AB/104/19/L

Front elevation of The Old Ship depicting bulging flintwork and failed plinth render.

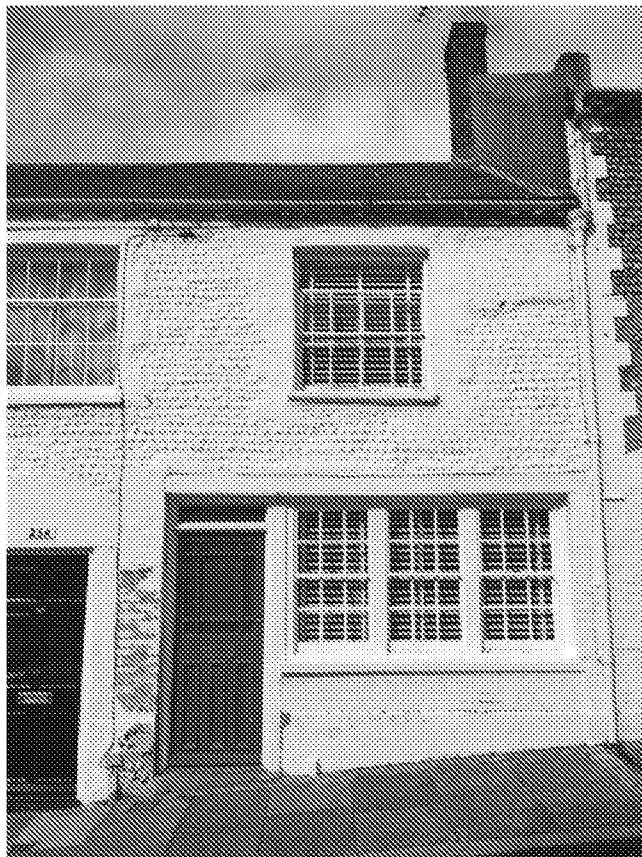
Works to the roof should only remove that historic fabric which is beyond salvage. Other materials should ideally remain in-situ with new materials placed next to them so that the evolution of the works can be understood, and historic fabric retained.

I note references to the fact that the applicant is not sure if to re-paint the elevation or not. The properties along this particular terrace consist of a mixture of painted and un-painted flint elevations. Whilst either approach may be acceptable, it probably should be that the elevation is repainted so that it reflects the immediate neighbouring property (number 25 King Street). The reason being this recommendation is that these properties were historically one unit. If the elevation is to be repainted, it should be undertaken using appropriate paint which will allow the building to breath.
